Rezoning Transportation Analysis
Petition Number: Insert Zoning Petition #2021-025
General Location Identifier: Tax ID 16511318

Revision Log:	Date	Description
	02-25-21	First Review (LJ)
	03-25-21	Second Review (WB)
	04-16-21	Third Review (KP)

Transportation Summary

RZ-1.0

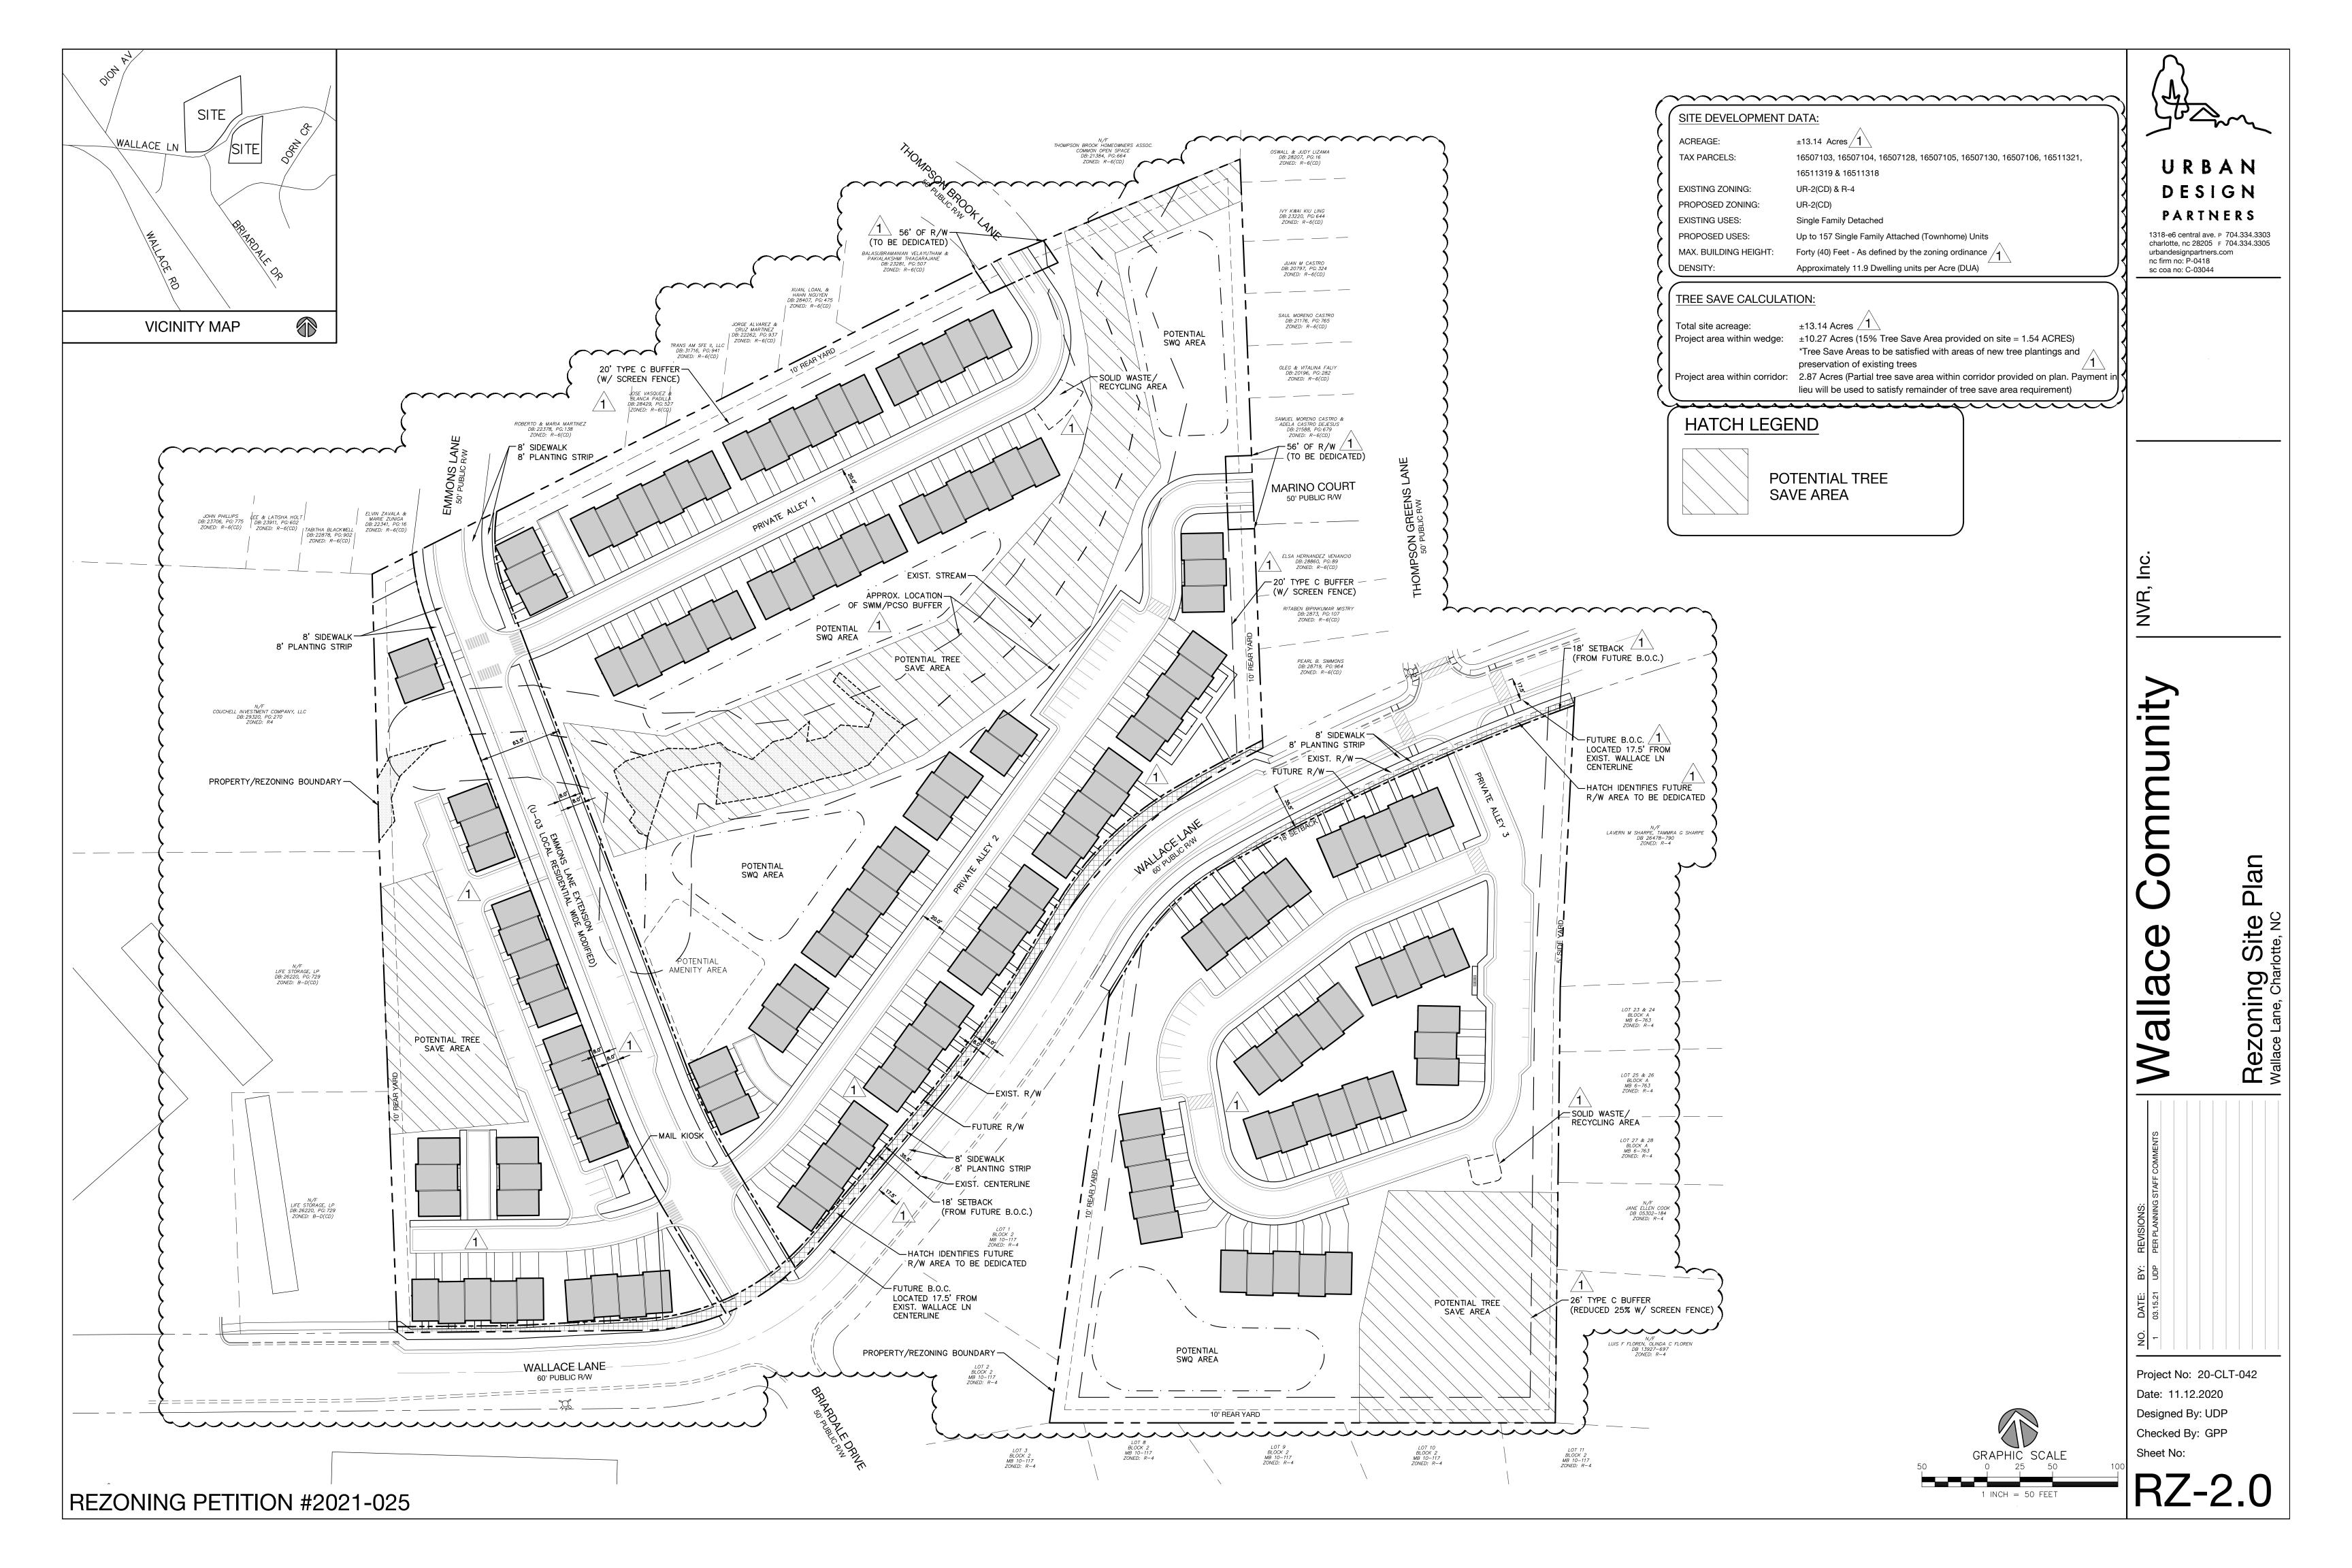
4. **OUTSTANDING (03/18/2021):** ~~Revise site plan and conditional note(s) to commit to construct an 8-foot planting strip, and 8-foot sidewalk on Wallace Lane and Emmon Lane extension per Chapter 19 / Chapter 20. The site plan shall label and dimension both items from the back of curb and gutter and road centerline. CDOT request of rights-of-way set at 2' behind back of sidewalk where feasible.~~

5. **OUTSTANDING (03/18/2021):** ~~Revise site plan to provide for Private Alley 1 and Private Alley 2 to be private streets, as opposed to alleys, to allow for better connection to the existing public road street stubs~~

7. **New Comment (03/25/2021):** Revise site plan and conditional note(s) to commit to constructing left turn lanes into the development per CDOT standards for developments that generate more than 500 trips a day.

Update to Comment as a Result of the 04-12-2021 Site Plan: Revise the site plan and conditional notes by committing to constructing a westbound left-turn lane, on Wallace Lane, onto Briardale Drive. This will provide a more fluid full-movement intersection.

- New Comment (03/25/2021):** Revise site plan to demonstrate adequate Intersection Sight Distance (ISD) at all proposed public street connections to existing Wallace Lane per CDOT Sight Distance Policy and to ensure safe ingress and egress into the development. ISD must be shown in both horizontal and vertical dimensions (plan/profile) along the sight line, not the roadway centerline.

Update to Comment as a Result of the 04-12-2021 Site Plan: Revise the ISD Profile for Emmons Lane Extension and Wallace Lane to depict Stopping Sight Distance Profiles in addition to Intersection Sight Distance Profiles. Additionally, revise the ISD Profile for Private Alley 3 and Wallace Lane to show the left-turn sight line profile.
